Ribble Valley Borough Council
Development Control

Application no: 3/2019/1138
Address: Lincoln Way Clitheroe
Proposal: Amended Layout Building 7

SITE LAYOUT PLAN

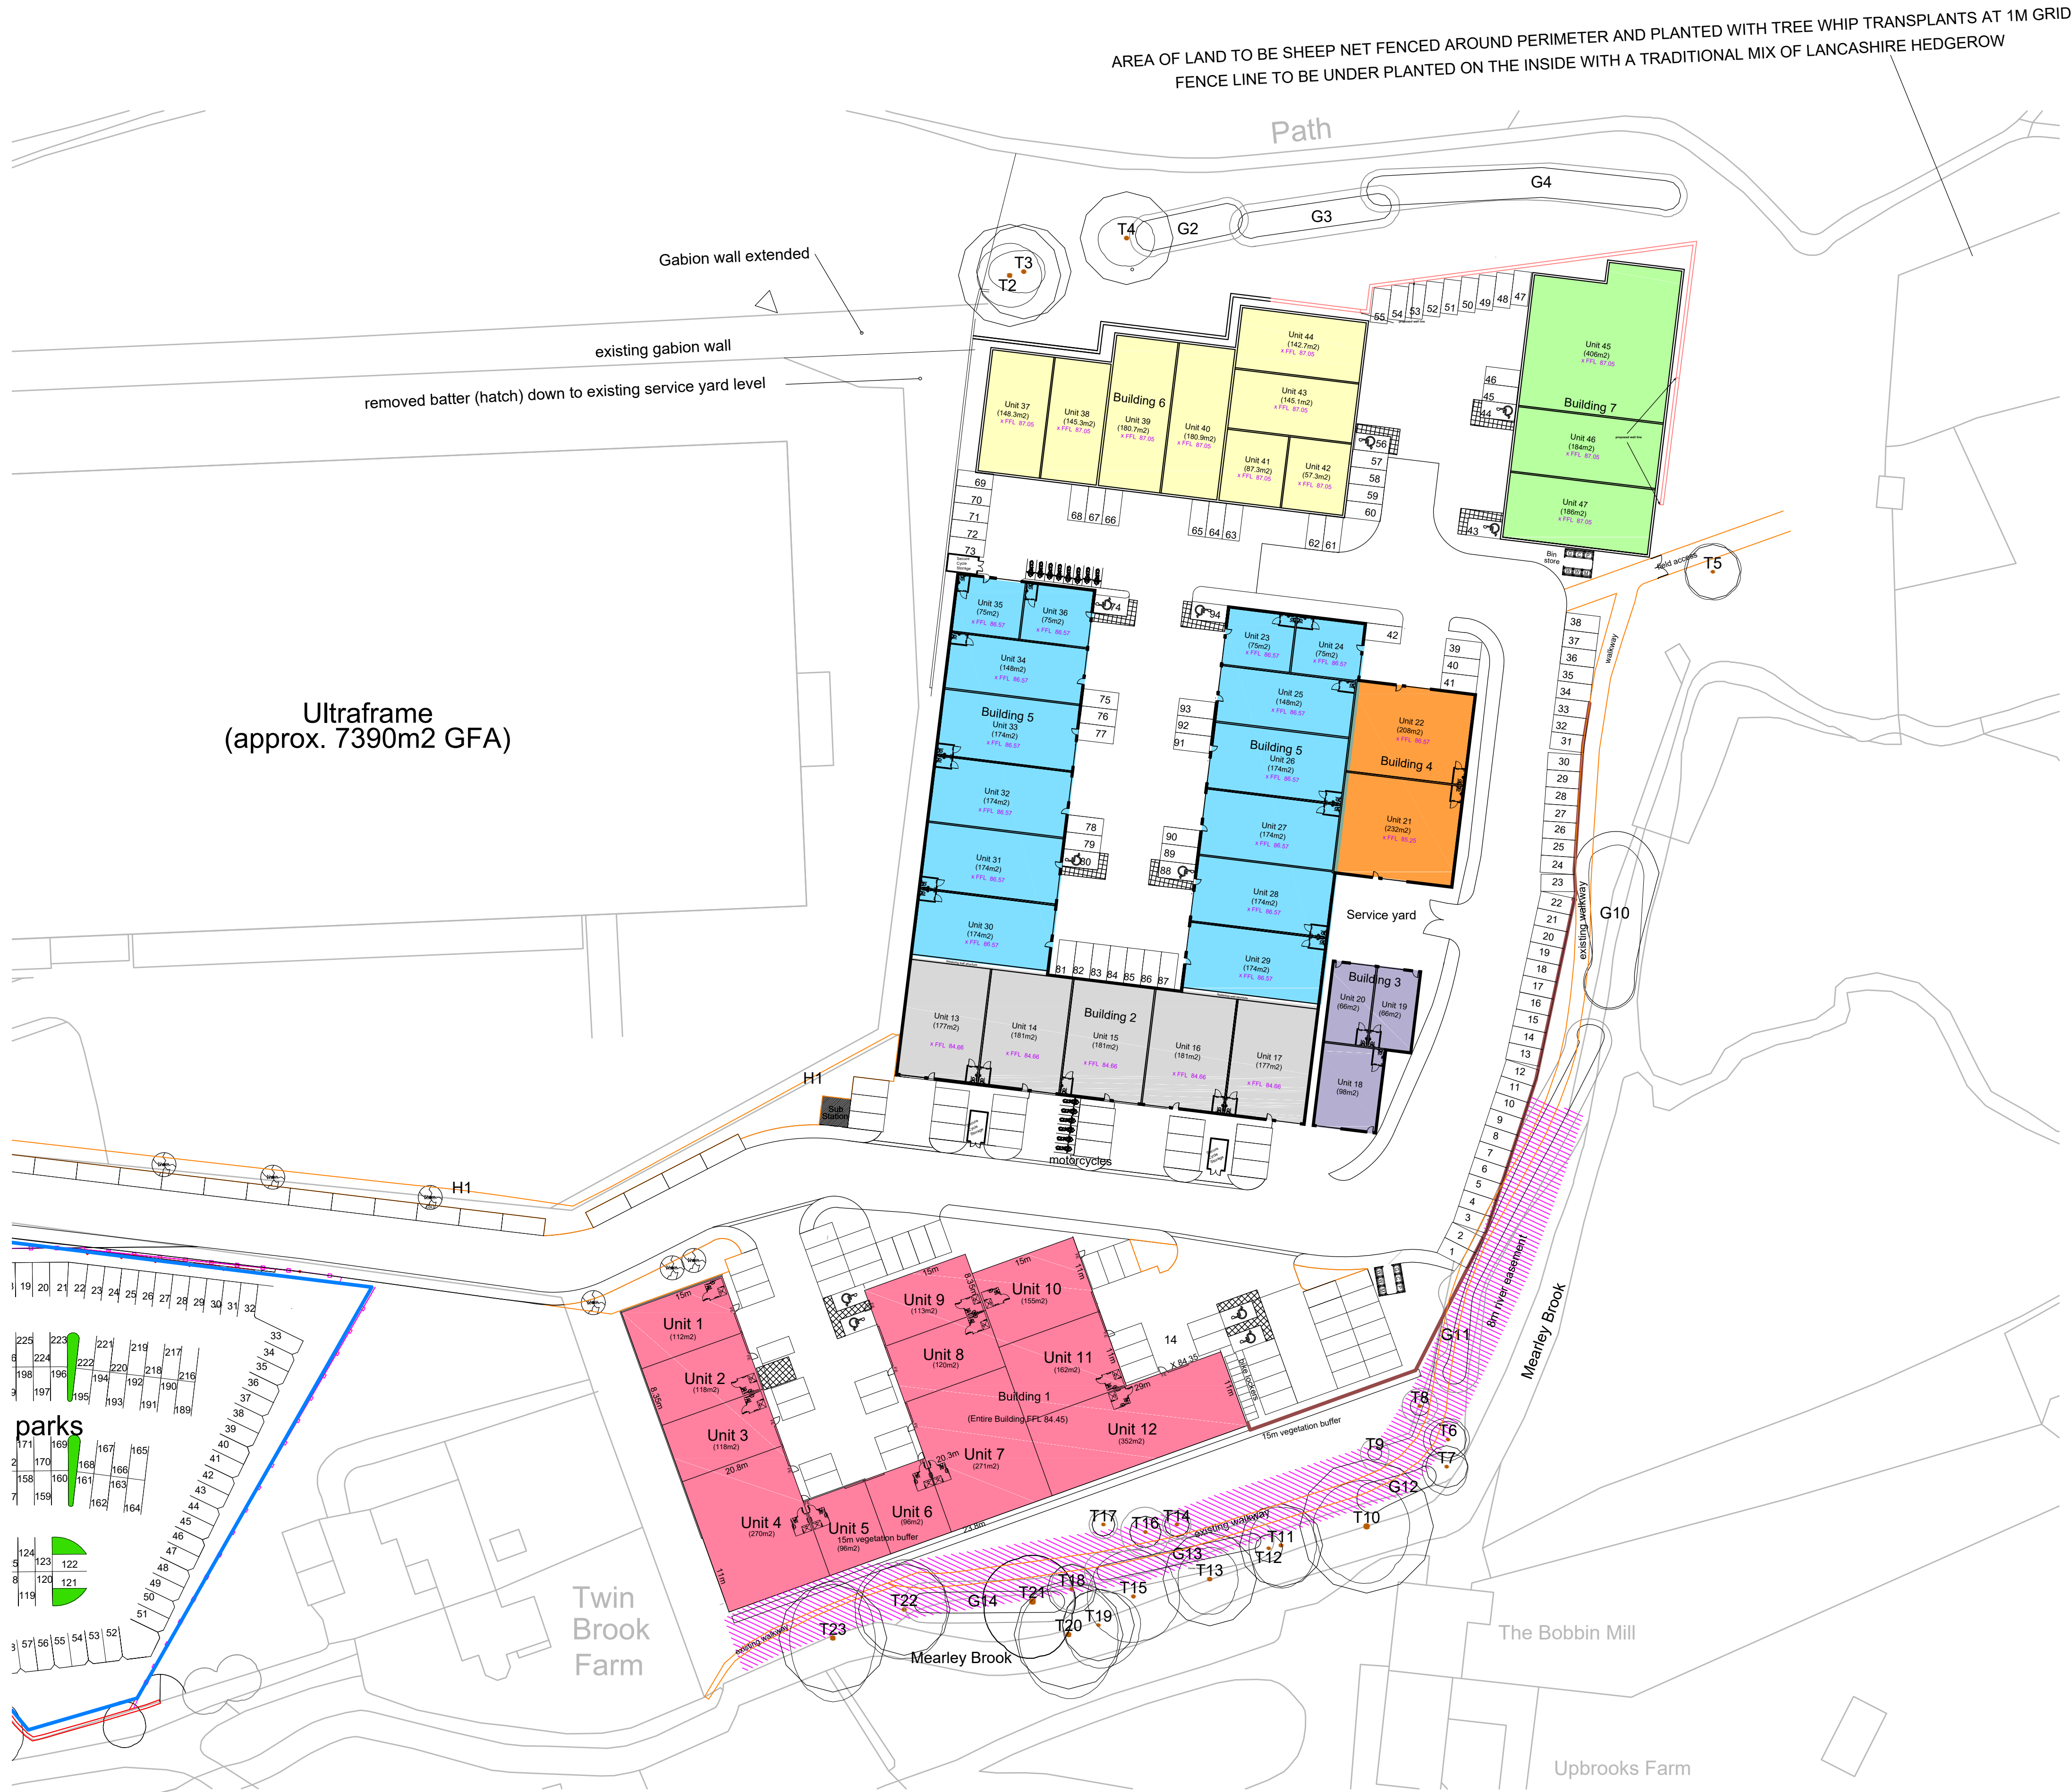
As proposed the amended layout will reduce the availability of parking in this area of the overall development from 33 to 23. Of the 23 proposed I would have safety concerns in respect of spaces numbered 46 – 48 as these are located on a bend with reduced visibility for on-coming traffic and the reduced carriageway width at this location. For a development of this size a parking provision of 22 vehicles. Resulting in a shortfall of 2 vehicles. The applicant makes the point that there is a current application for the replacement of an office block with industrial units. This in itself would provide a parking saving of 10 spaces which is sufficient to offset the parking deficit for the application currently being considered. This would only be applicable if application 19/1030 subsequently receives planning approval.

In respect of the layout shown, the removal of spaces 46-48 would allow the carriageway to be widened on the bend. The current layout should be supported by the submission of revised swept path plans as should any revised proposals in this area.

Other areas of concerns are the siting of the bin store and the field access point.

The bin store should be relocated. During collection the refuse vehicle would obstruct through traffic on the bend.

Proposals for a field access at this location were included in the original submission. What is the justification for this at this time and would pedestrian access be permitted/ accommodated?
